About the application

Application number: 2025/92331	
What is the application for?:	Variation of conditions 3 (use of floors) and 4 (operating hours) of previous pe
Address of the site or building:	Almondbury Working Mens Club, Southfield Road, Almondbury, Huddersfield, HD5 8RY
Postcode:	HD5 8RY

DRAWING TITLE  
Approved & Proposed Elevations

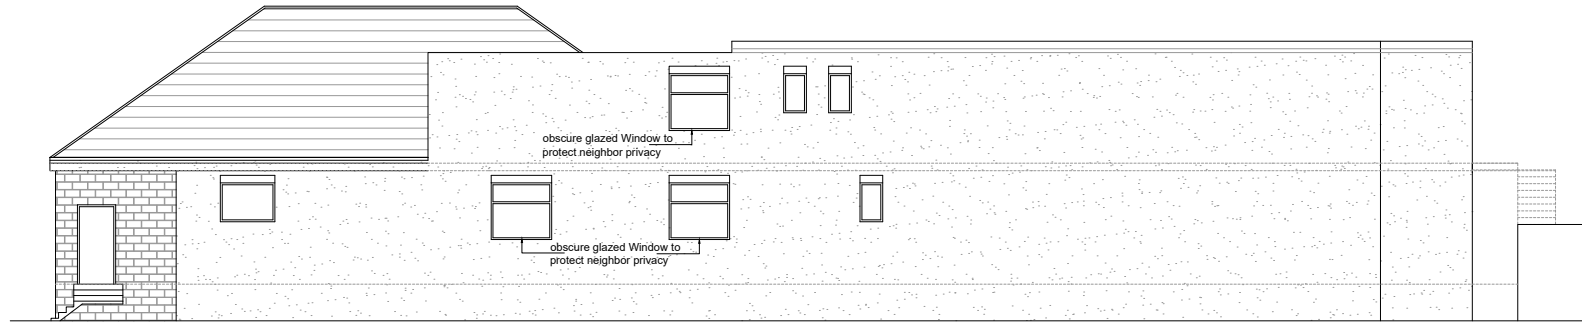
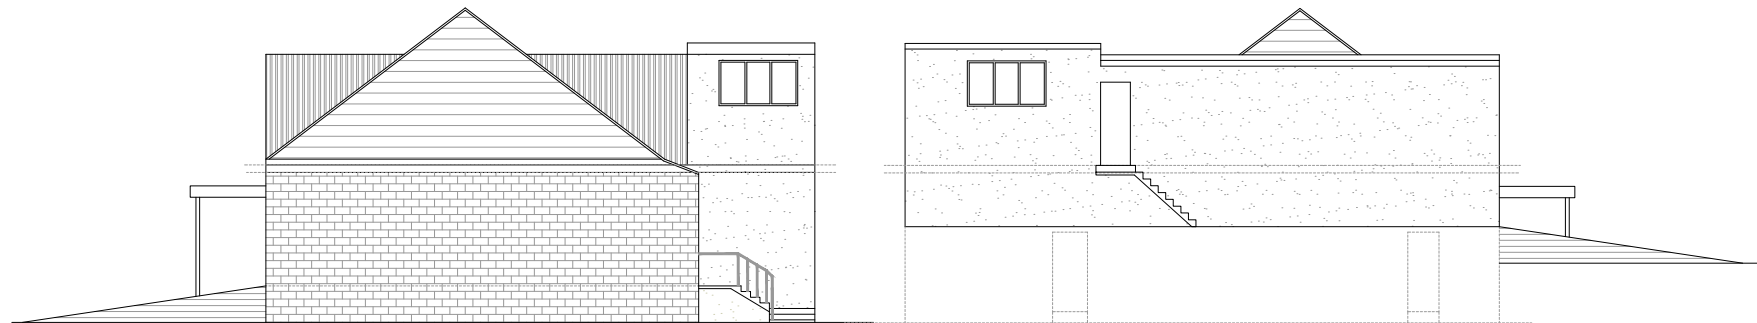
Type of comment: An objection	
Do you wish your comments to be published on the website anonymously?	<input type="checkbox"/> Yes
<p>One of my main worries is the new windows being added — they directly overlook my home and garden, which affects my privacy. I've lived here for over 30 years and have always valued the peace and privacy of my space.</p> <p>I'm also concerned about a door that's been fitted above the old toilet block. It leads onto a flat roof that looks straight over my garden and several others. I'd really like to know what the purpose of that door is and whether it's going to be used as access or some kind of outdoor area. They're also proposing a fenced-off area at the front of the building, which would be right next to a very busy road. Traffic on that stretch is already slow-moving and congested during school and work run times, and I don't see anything in place to manage the flow or improve safety.</p> <p>The plan to turn part of the building into a nursery is also a concern. There are already a number of nurseries in the area, and adding another one could increase noise, parking issues, and traffic problems on an already busy street.</p> <p>Lastly, even though work has already started, it hasn't gone smoothly — my neighbour has had their property damaged by paint or sprayed materials coming from the site. That's not acceptable and raises concerns about how future work will be handled.</p> <p>I'd be grateful if all these points could be considered before any decisions are made.</p>
